Our Ref: EP/97/12/

26th October 2012

Side two storey extension, front dormer, front porch and new detached garage
2 Elm Avenue East Preston

SITE PLAN 1:500 SCALE.
08/09/2012

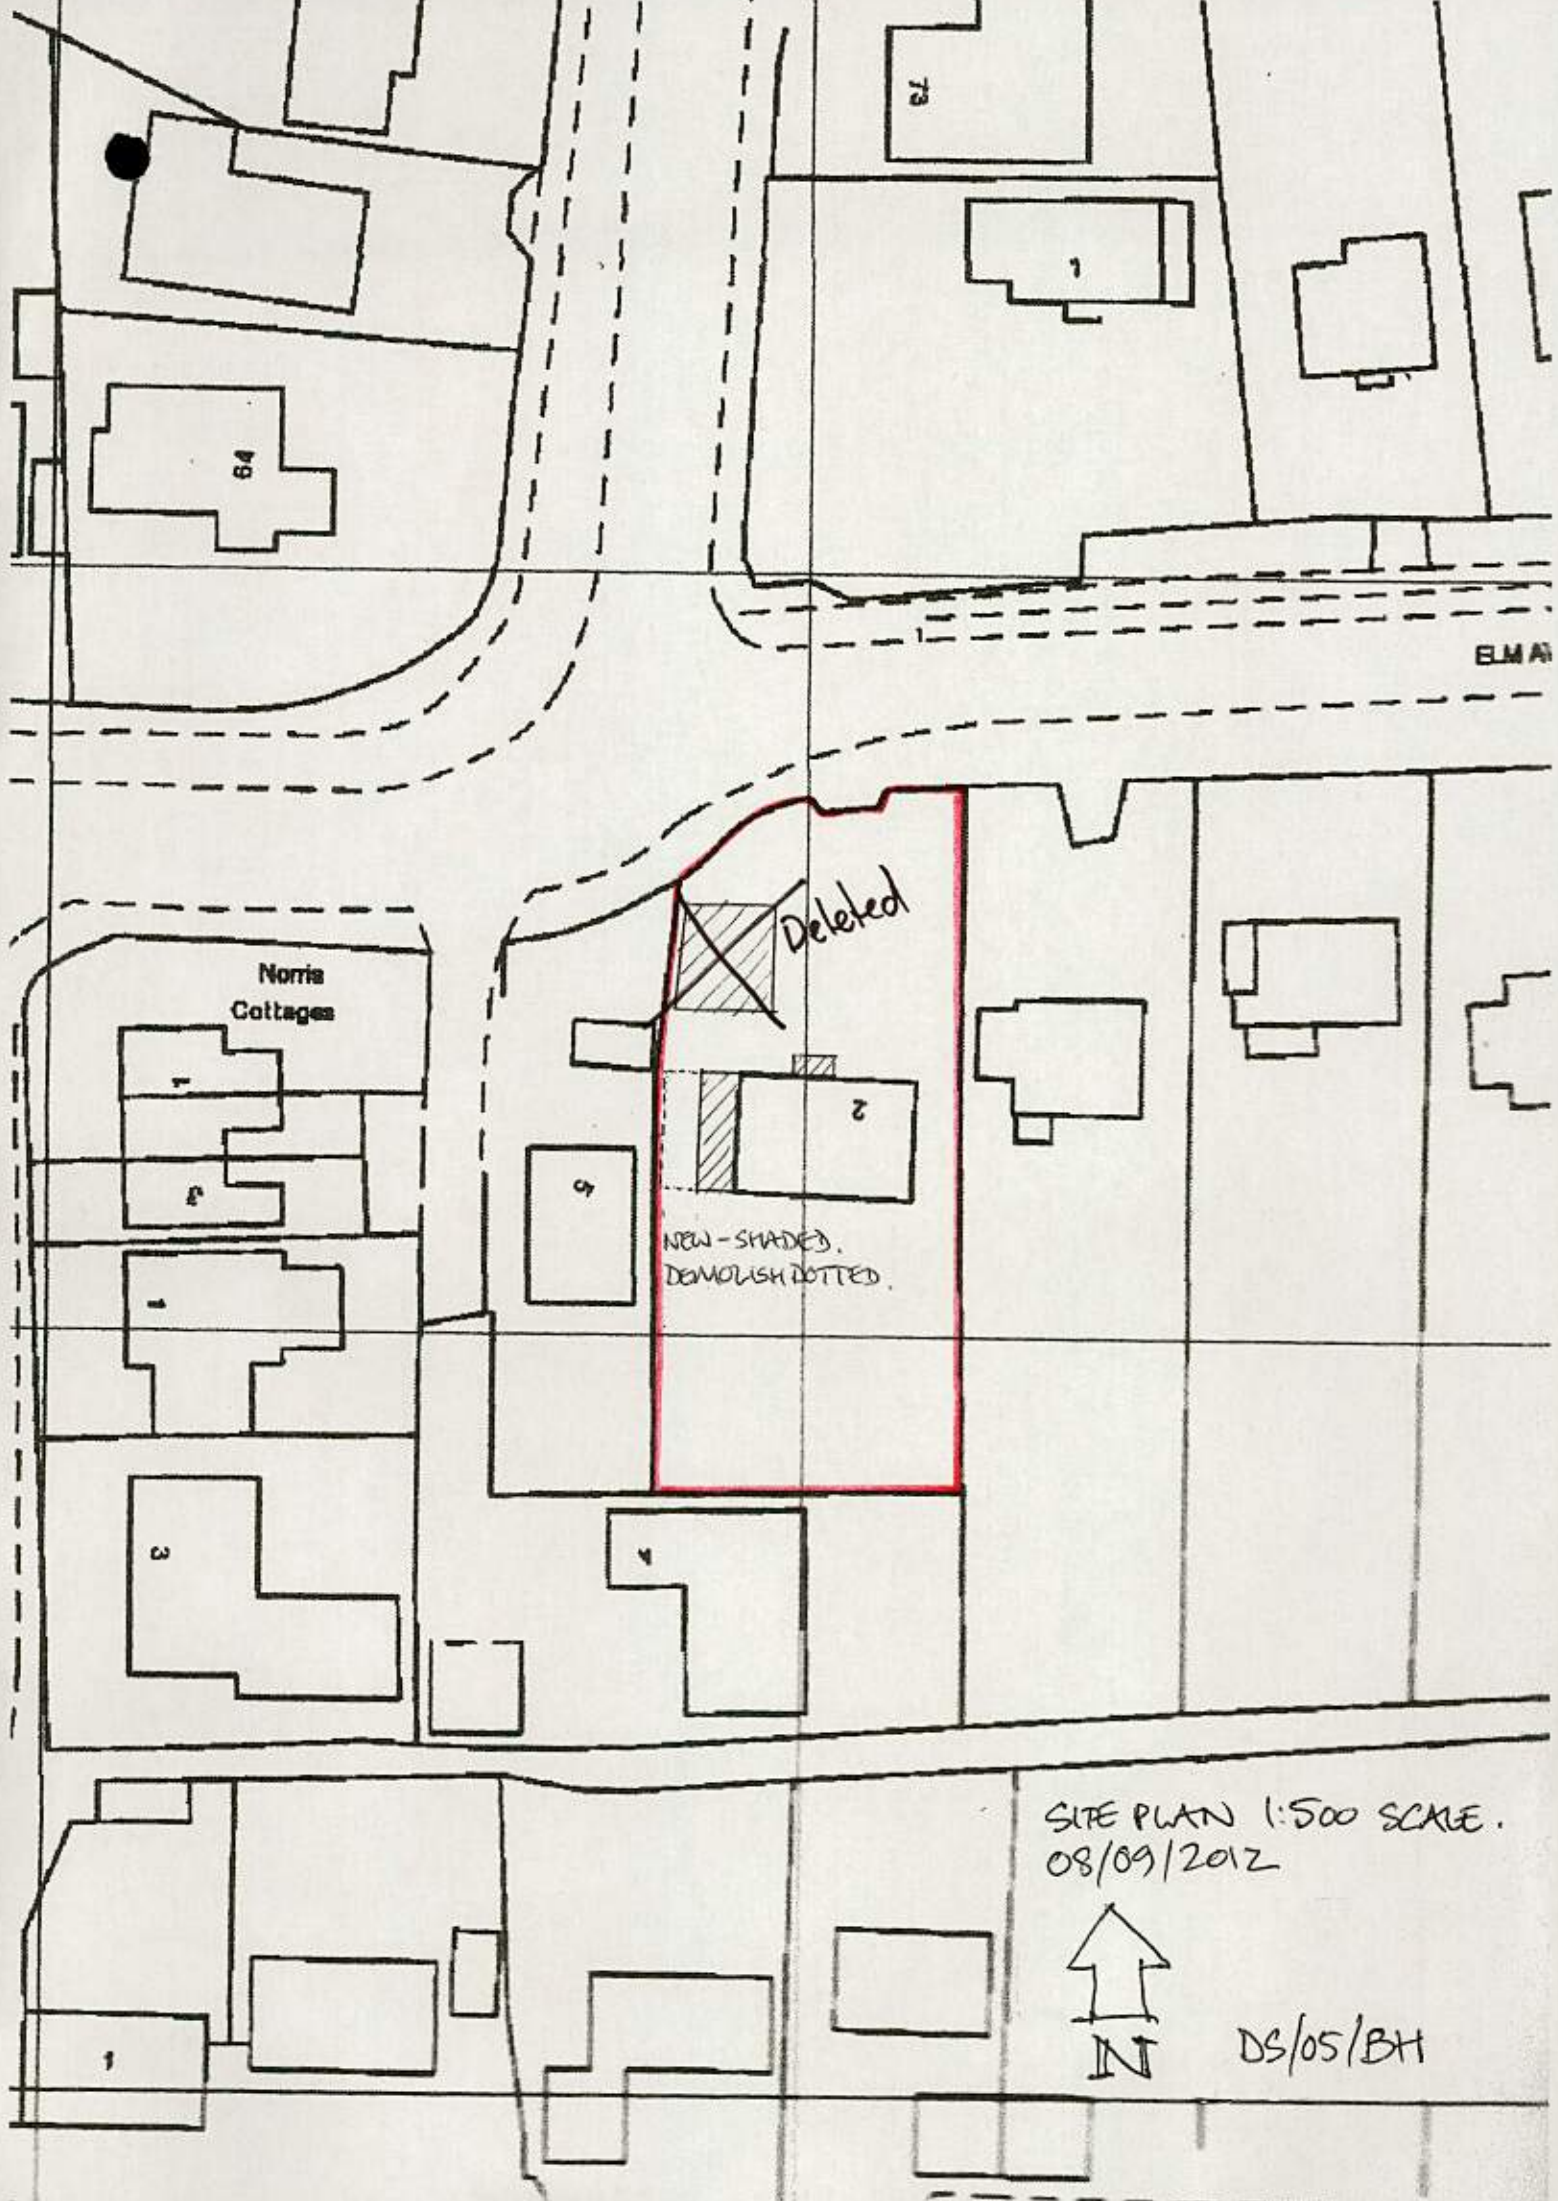
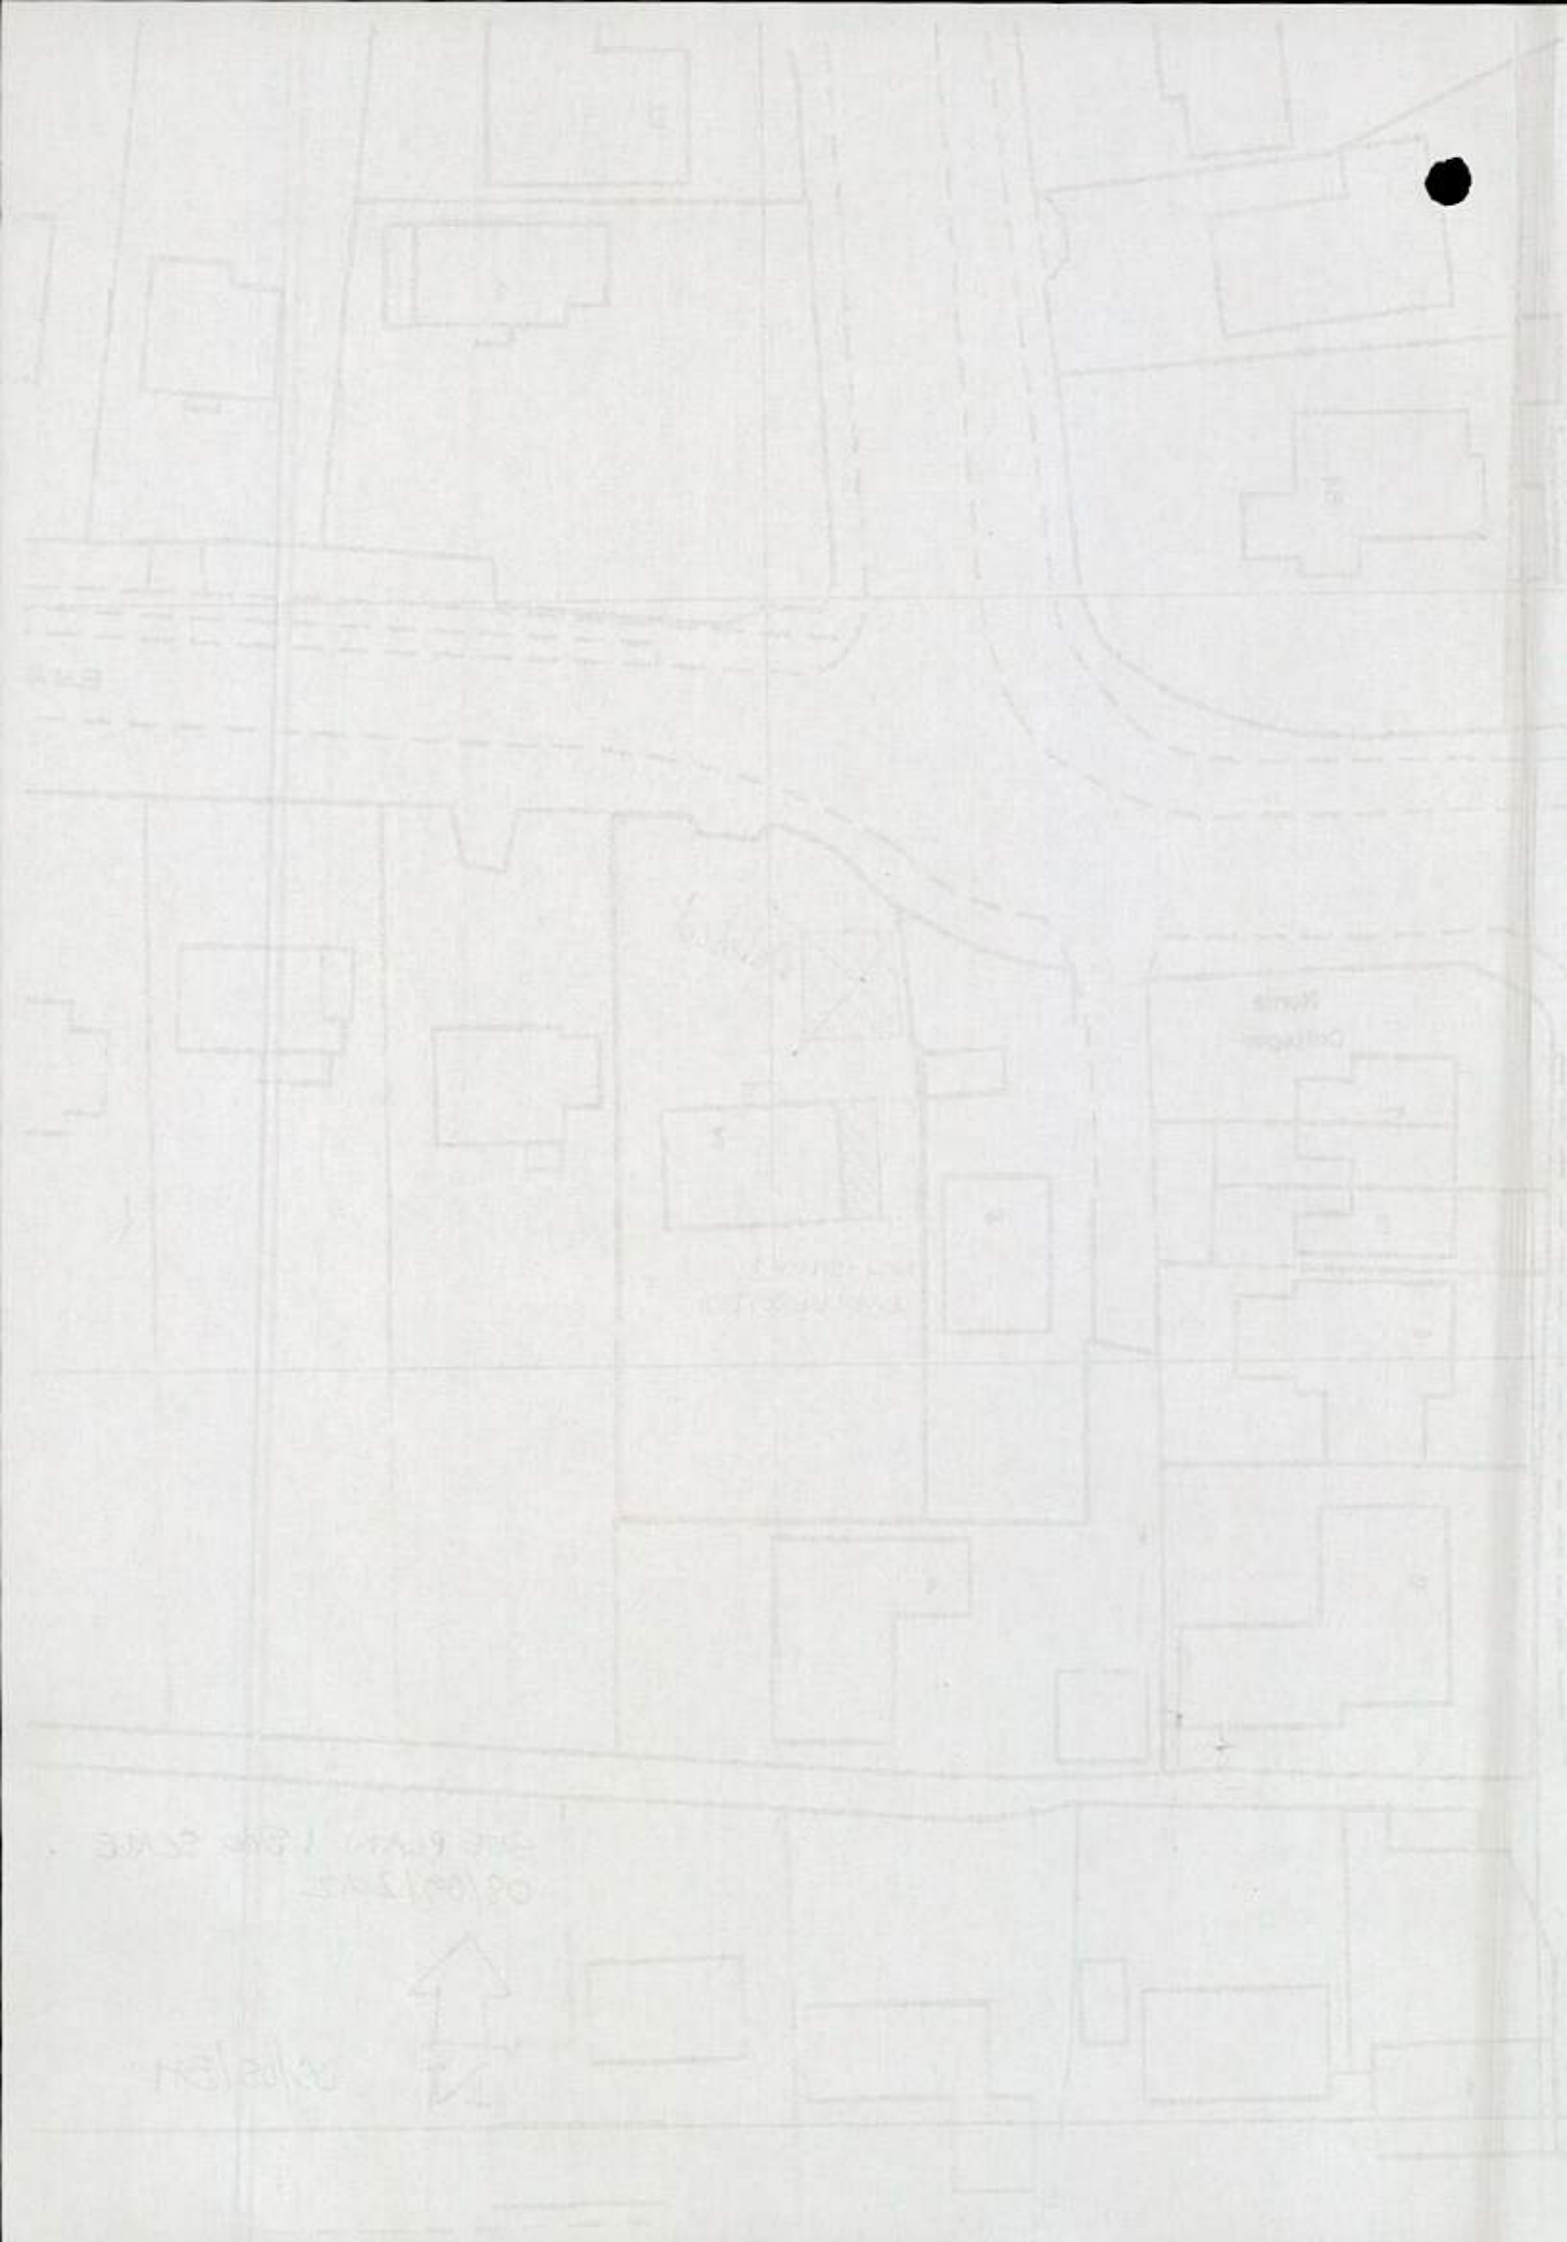
1. The position of the new garage, close to the road and ahead of any existing buildings in the road, would conflict with policy GEN7, because it does not respond positively to the characteristics of the site; with policy DEV19, because it affects the spatial character and pattern of the street; and with the guidance concerning the Elm Avenue Area of Special Character, which emphasises the importance of the regular building line in the area.

For these reasons, this application should be refused. It might be acceptable if the garage
